From: Ian Stocks [REDACTED] **On Behalf Of** FRS Water and Access
Sent: 29 June 2021 16:37
To: Planning.Responses <Planning.Responses@arun.gov.uk>
Subject: Hydrant condition - AL/75/21/PL Lidsey Lodge Farm Sack Lane Lidsey PO22 9PE

HYDRANT CONDITION CONSULTATION WITH PLANNING AUTHORITY

Planning Ref: AL/75/21/PL

Address: Lidsey Lodge Farm Sack Lane Lidsey PO22 9PE

Project Name: Lidsey Lodge Farm
Drawing: Site layout and block plan
Drawing Number: 2020/10/11

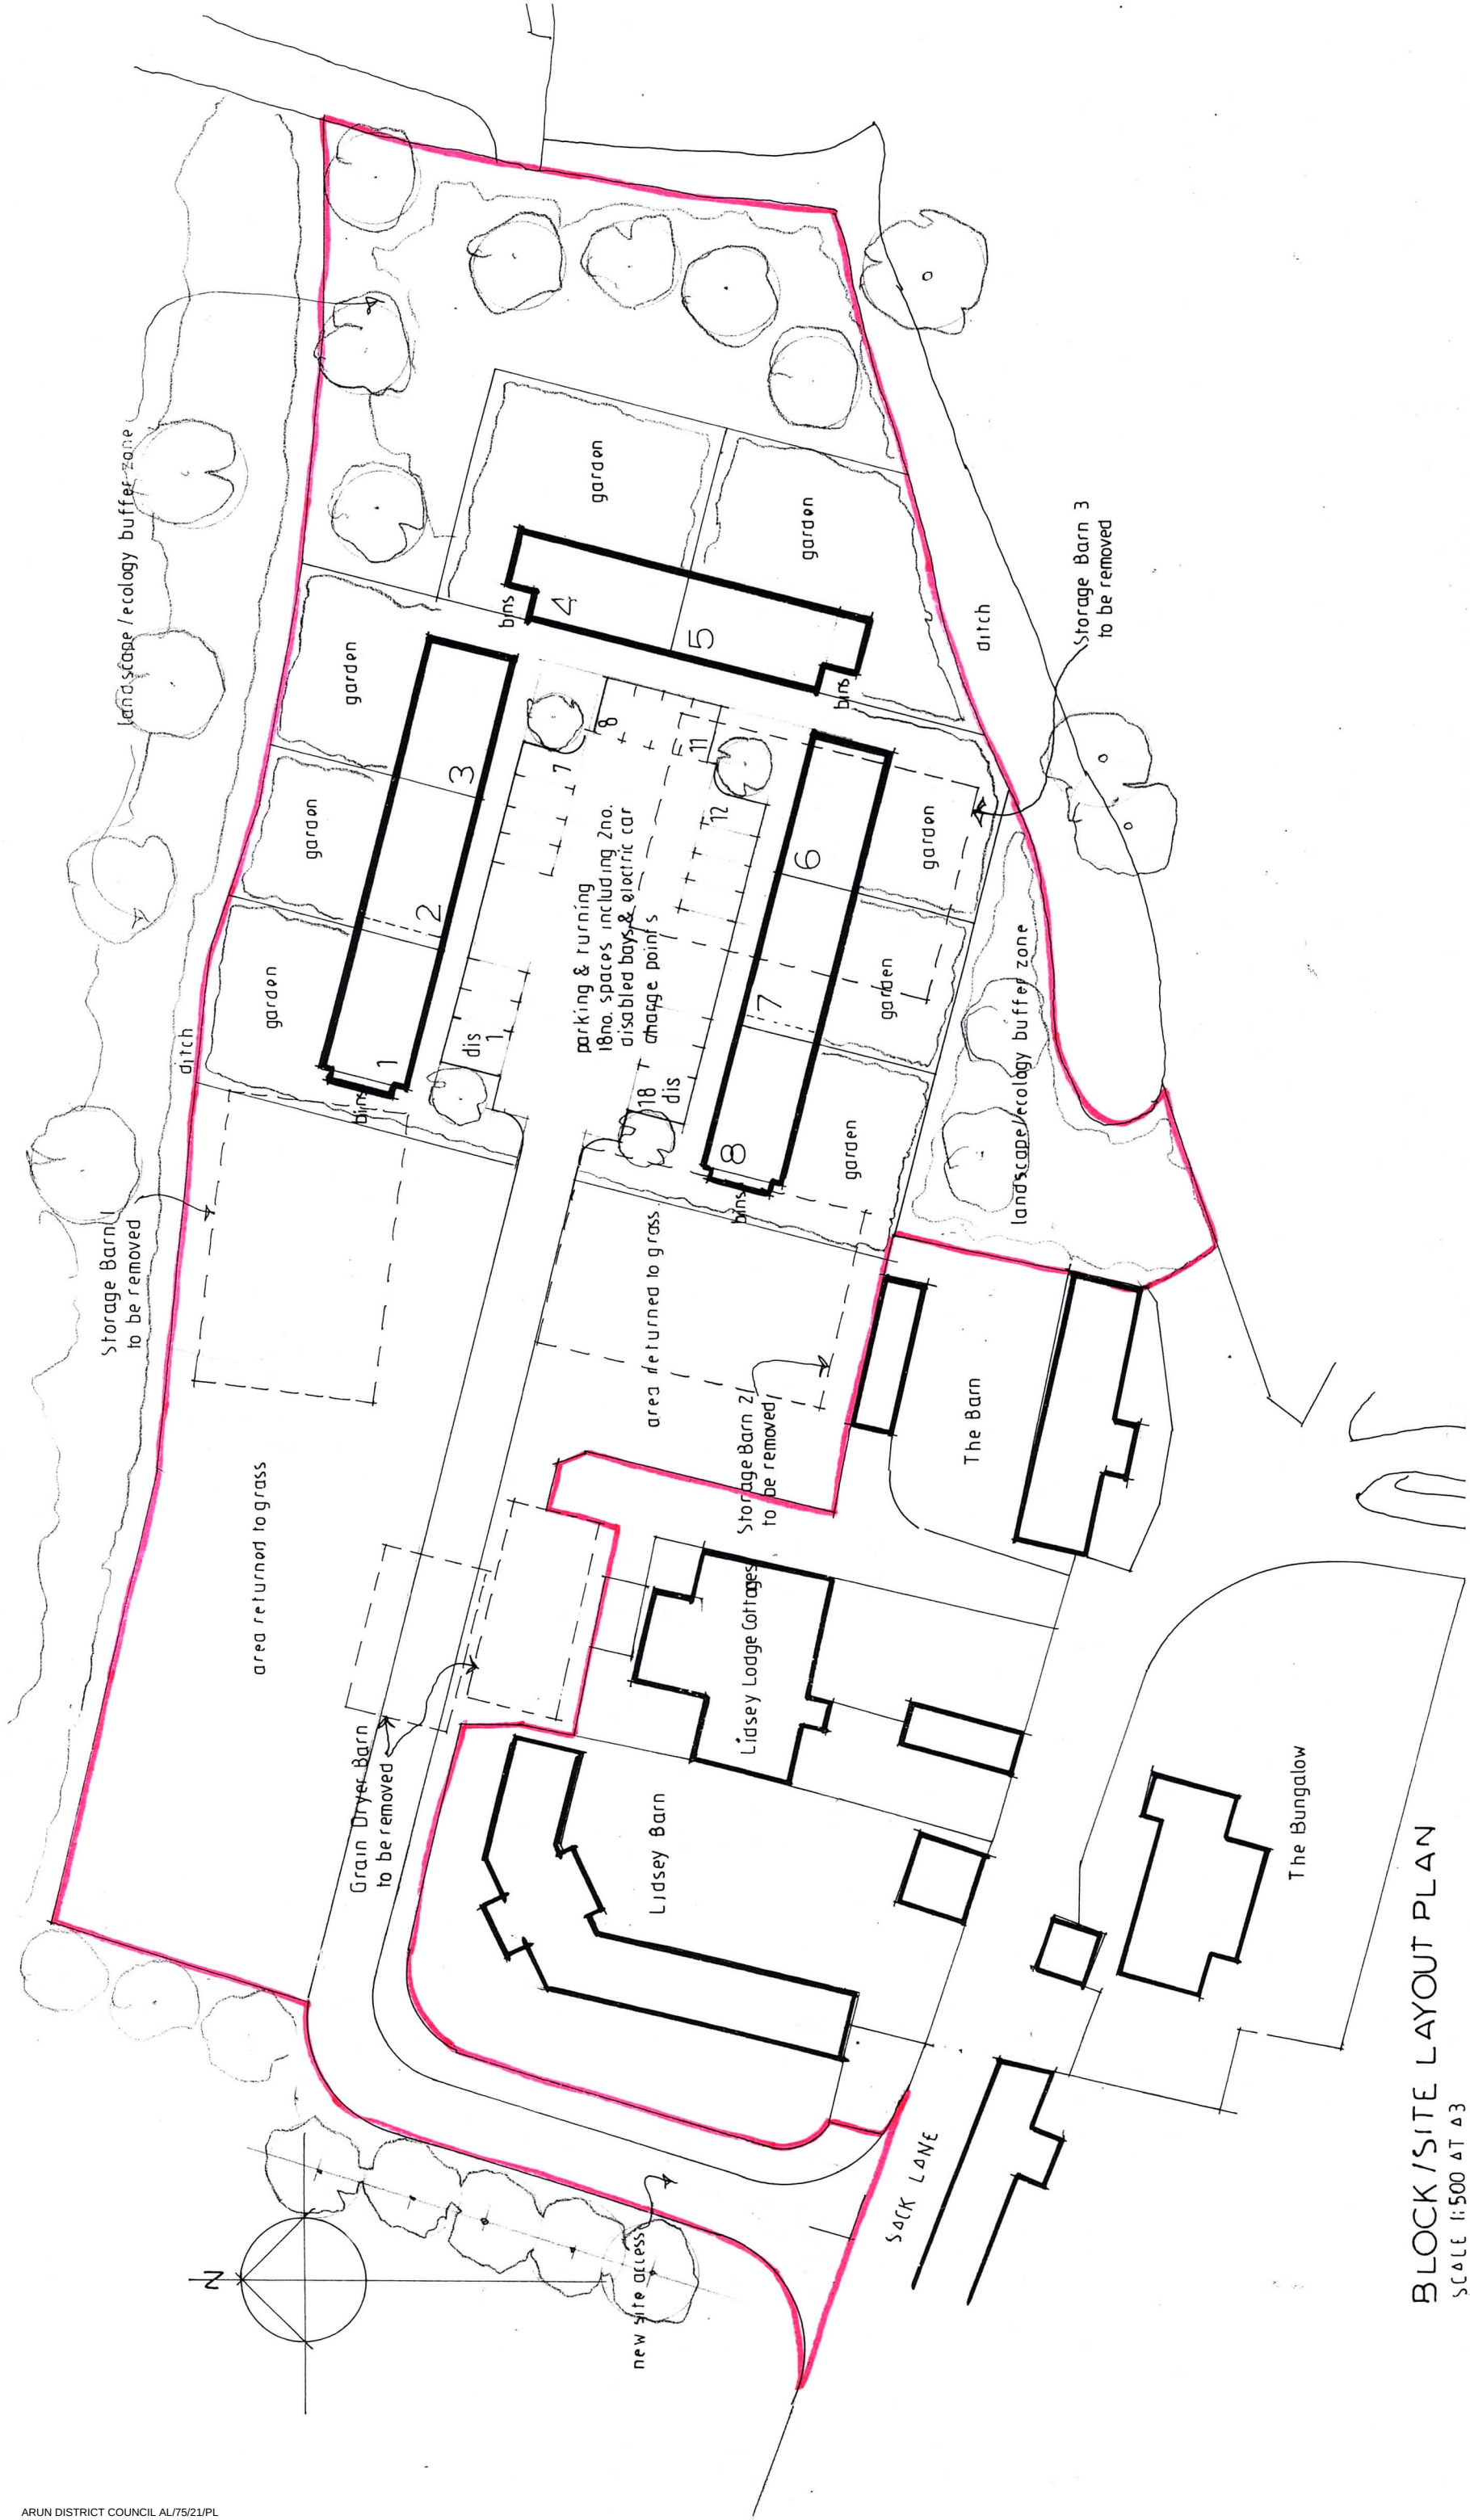
Please find attached a planning condition for application no. AL/75/21/PL for the requirement of an additional fire hydrant. Currently the nearest Hydrant to these proposed properties is 350 metres away. The supply of water for firefighting for a domestic premises should be within 175 metres.

Evidence will also be required that Fire Service vehicle access meets with the requirements identified in Approved Document B Volume 1 2019 Edition: B5 Section 13, including Table 13.1 and diagram 13.1.

- 1) Prior to the commencement of the development details showing the proposed location of [1] one fire hydrant or stored water supply (in accordance with the West Sussex Fire and Rescue Guidance Notes) shall be submitted to and approved in writing by the Local Planning Authority in consultation with West Sussex County Council's Fire and Rescue Service. These approvals shall not be unreasonably withheld or delayed.
- 2) Prior to the first occupation of any dwelling/unit forming part of the proposed development that they will at their own expense install the fire hydrant (or in a phased programme if a large development) in the approved location to BS 750 standards or stored water supply and arrange for their connection to a water supply which is appropriate in terms of both pressure and volume for the purposes of firefighting.
